TRINITY RANCH

WATER RESOURCES REPORT

for
Trinity Ranch Subdivision

July 28, 2026

EXHIBIT A (page 1) - Proposed Plat Trinity Ranch

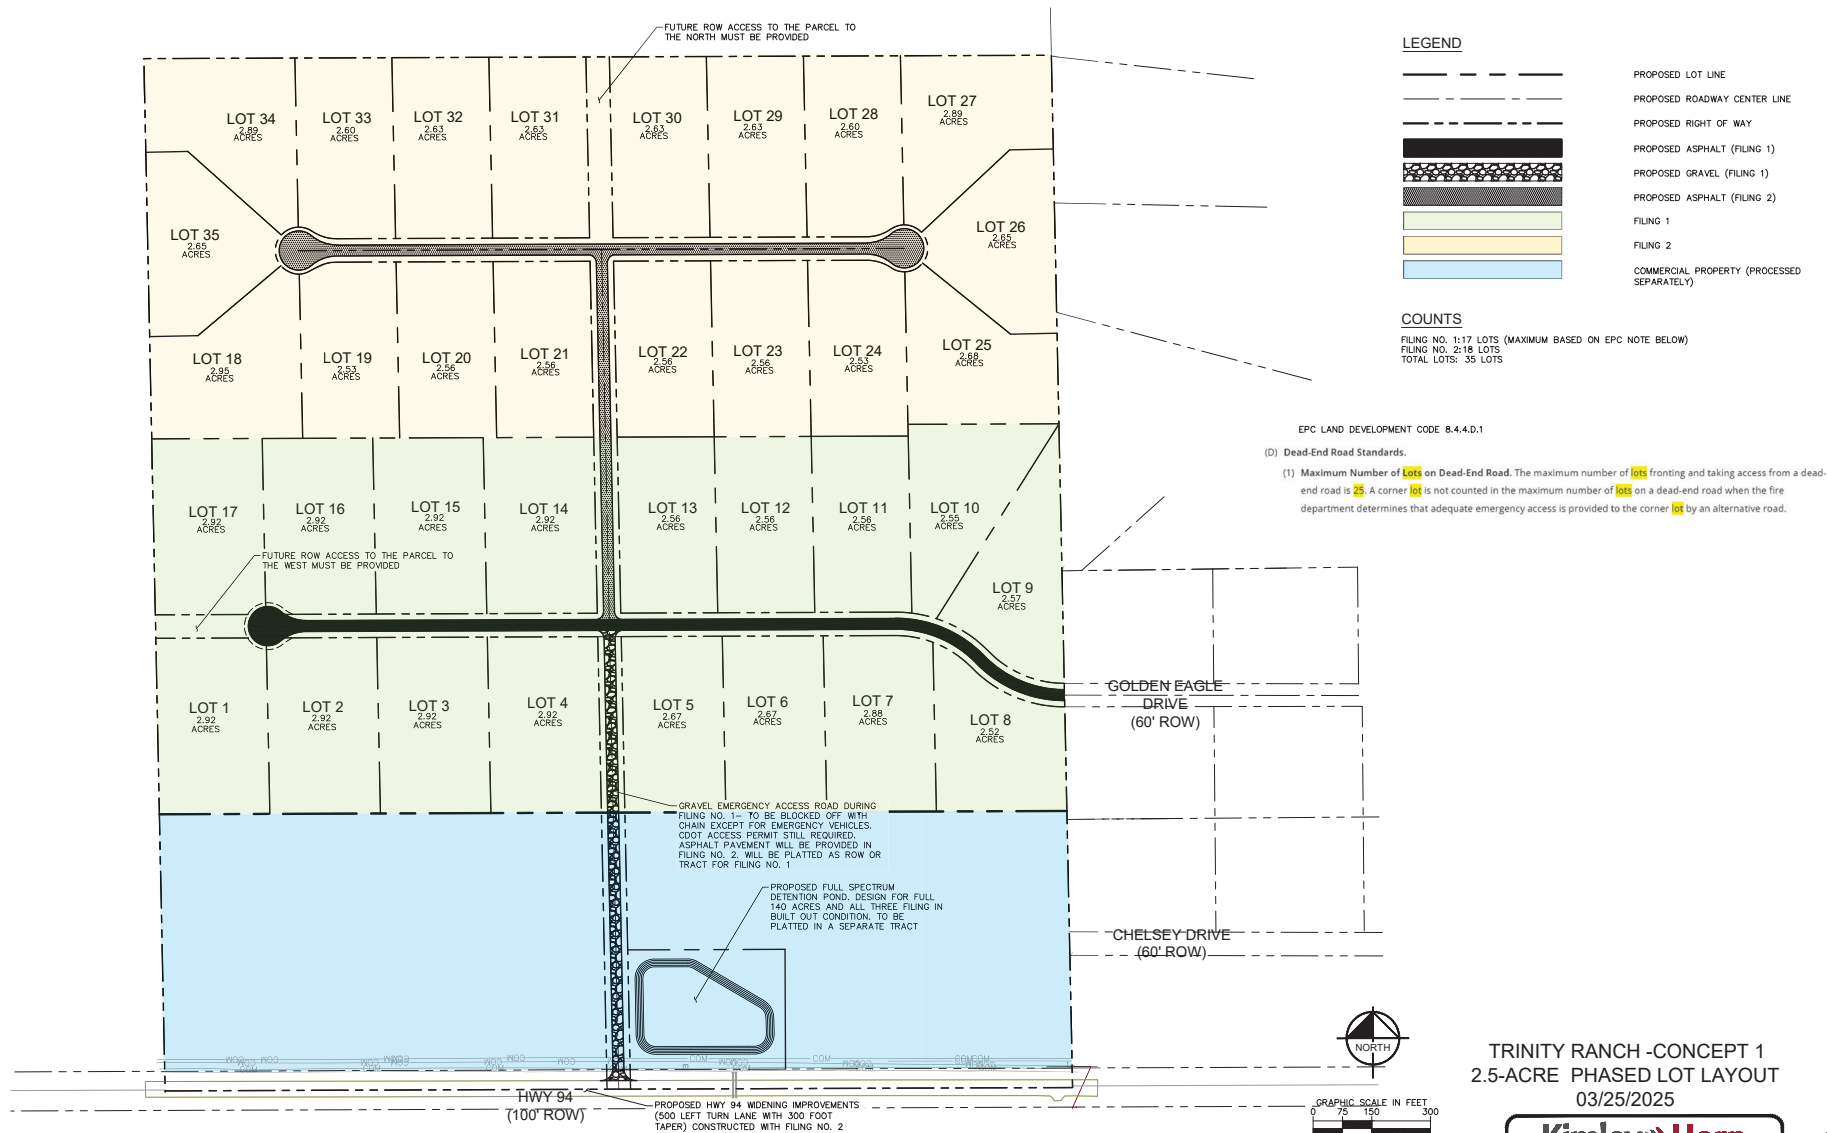
This report does not contemplate the commercial lots. The commercial area is included in the preliminary plan boundary, and therefore need to be contemplated. See comments on the prelim plan drawings for more information.
